Principal Areas of Disagreement Summary Statement (PADSS) from Buckinghamshire Council (BC)		Version Number: 4 Submitted at: 08/12/2023		
Principal Issue in Question		Concern held	What needs to change/be amended/be included in order to satisfactorily address the concern	Likelihood of concern being addressed during Examination

Figure 1 – Location of B488 / B489 Junction, Ivinghoe

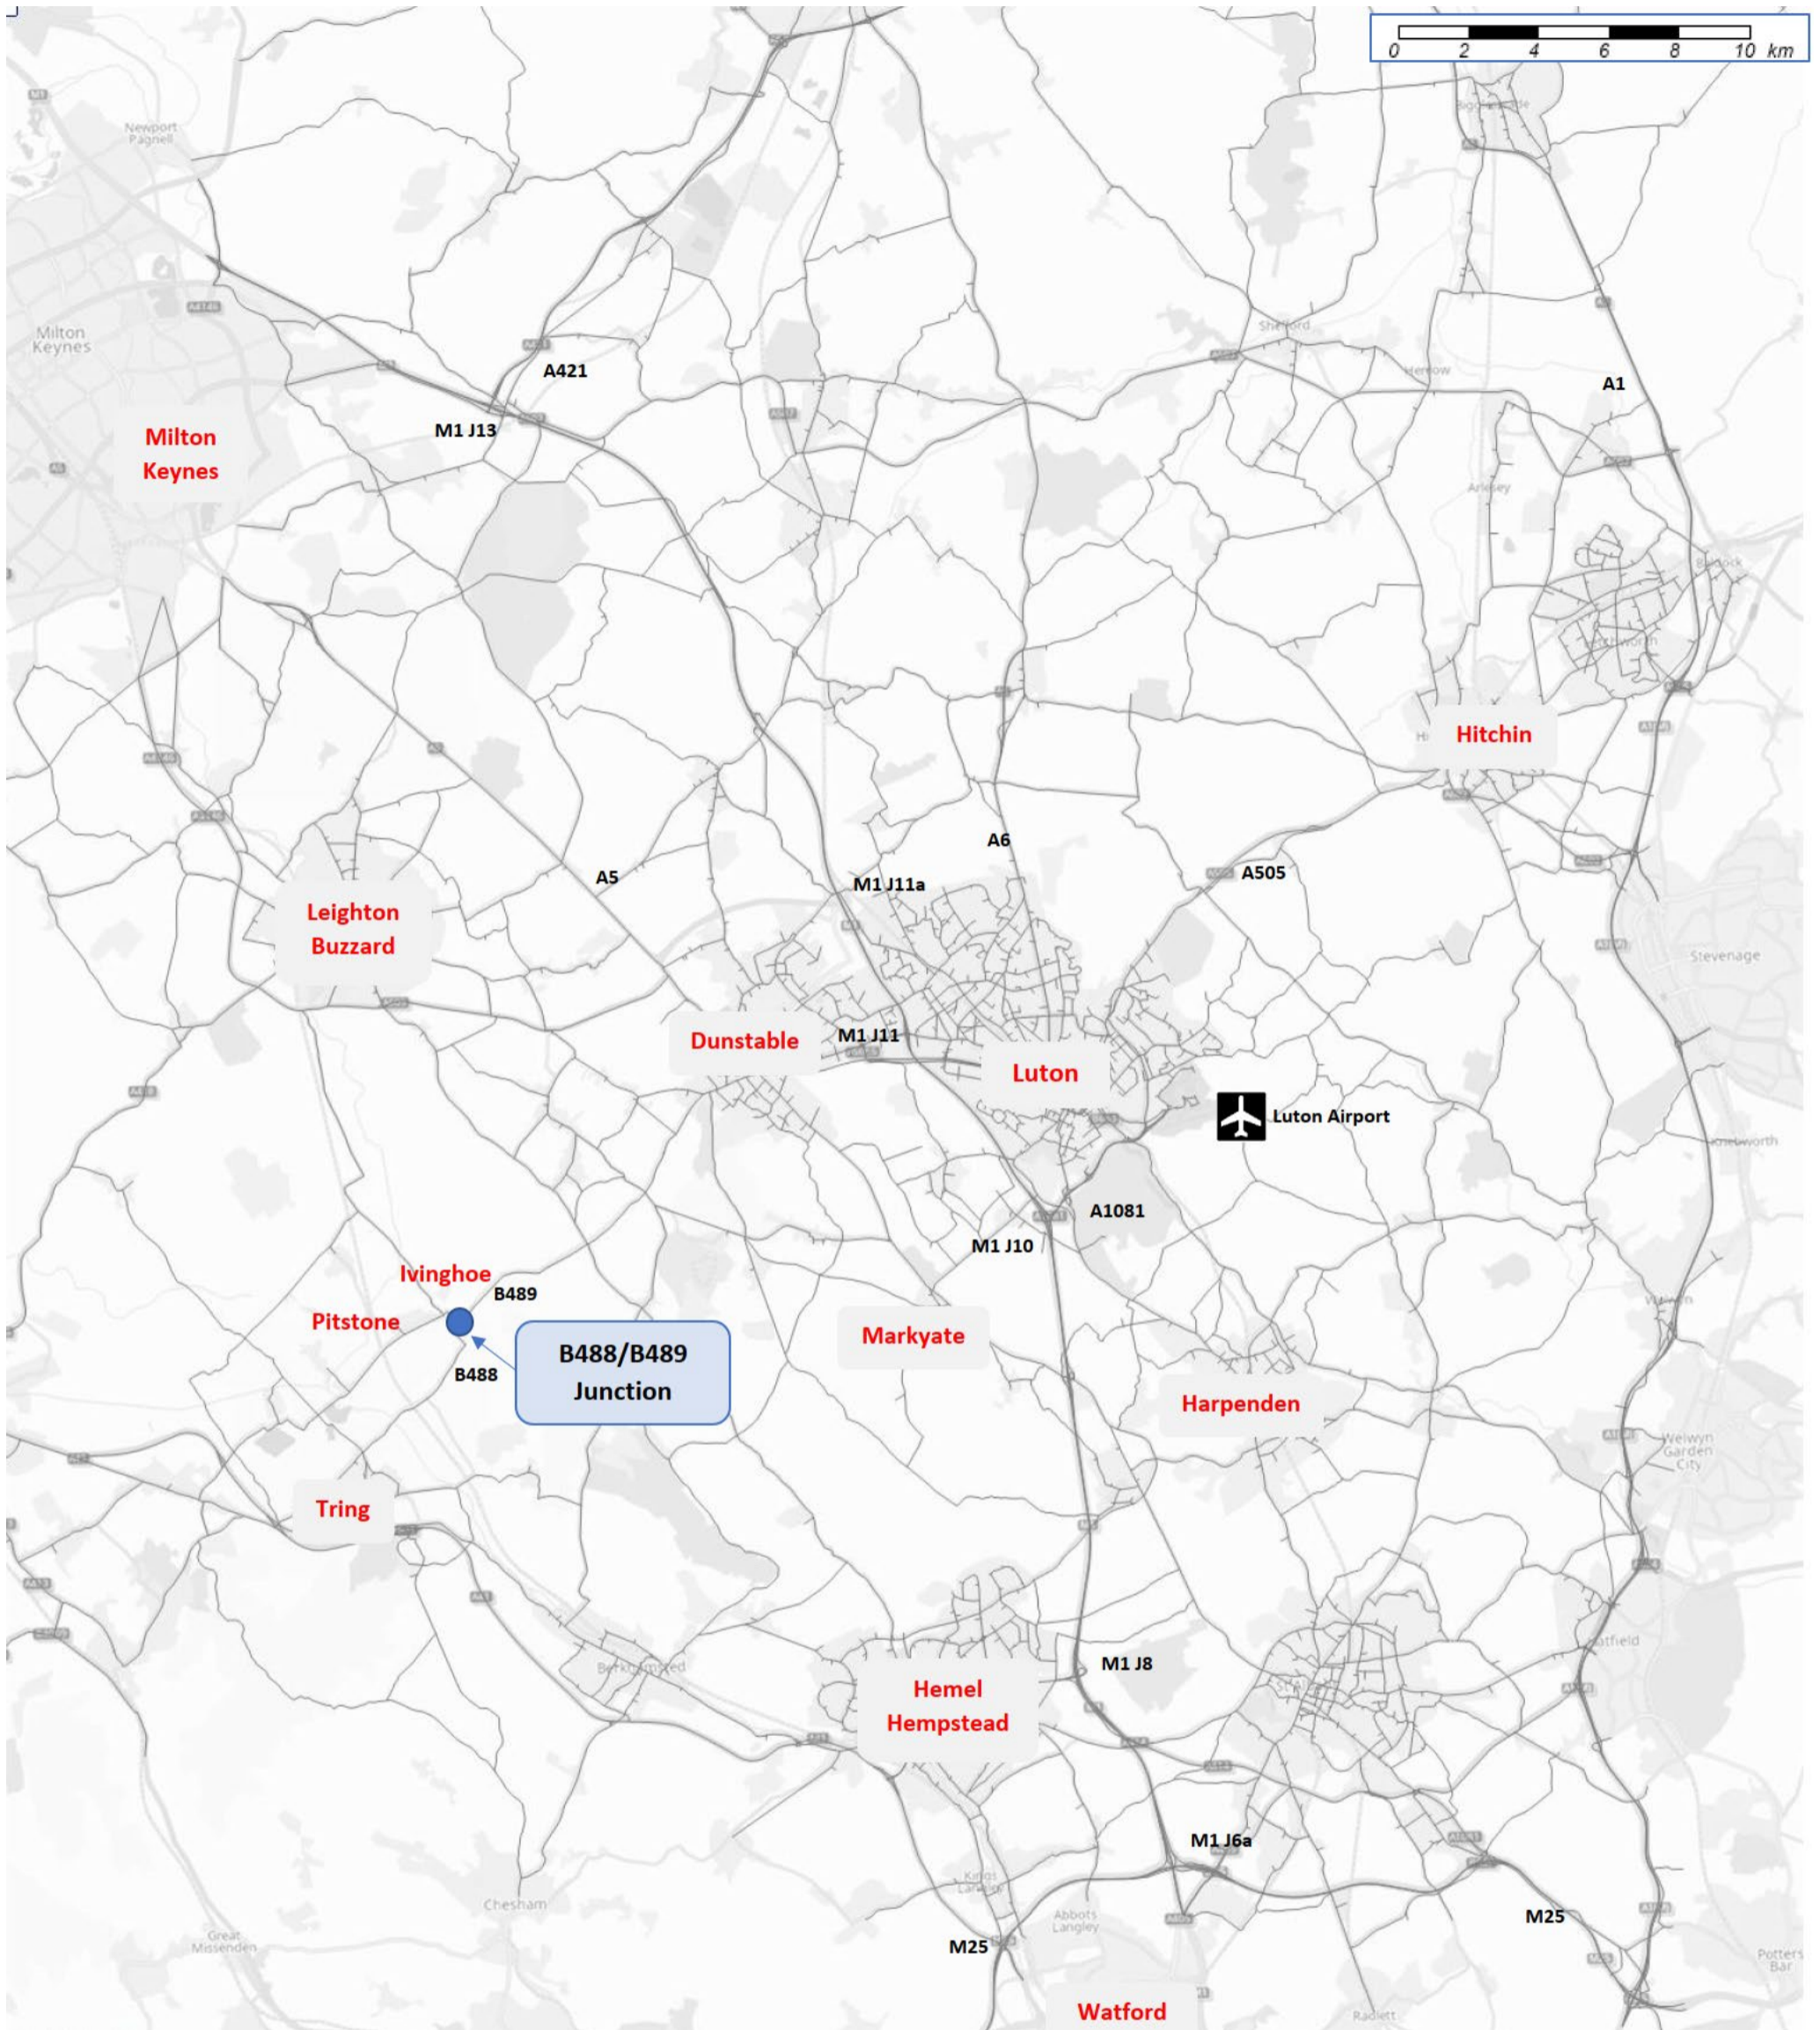
2.2.2	Robustness of traffic assessment data re: A41/B489/B488 route by the Applicant.	Concerns regarding the level of confidence that can be applied to the assessment of the A41/B489/B488 route by the Applicant.	Details of the link flows for the base year and future years with and without development for the B489, B488 and A41.	BC has engaged extensively with the Applicant on these matters as well as conducting additional survey work to support the Applicant's comparative data analysis, for which the Council is awaiting a response. BC willing to continue to engage positively with the Applicant with a view to addressing its remaining concerns within the Examination timeframe.
			Select link analysis of development traffic only for the B498, B488 and A41.	
			Reassessment of the A41/B489/B488 route using the results / findings of the comparative data analysis.	
			Mitigation and/or enhancement at the B488/B489 junction and other parts of the principal airport access route through Buckinghamshire.
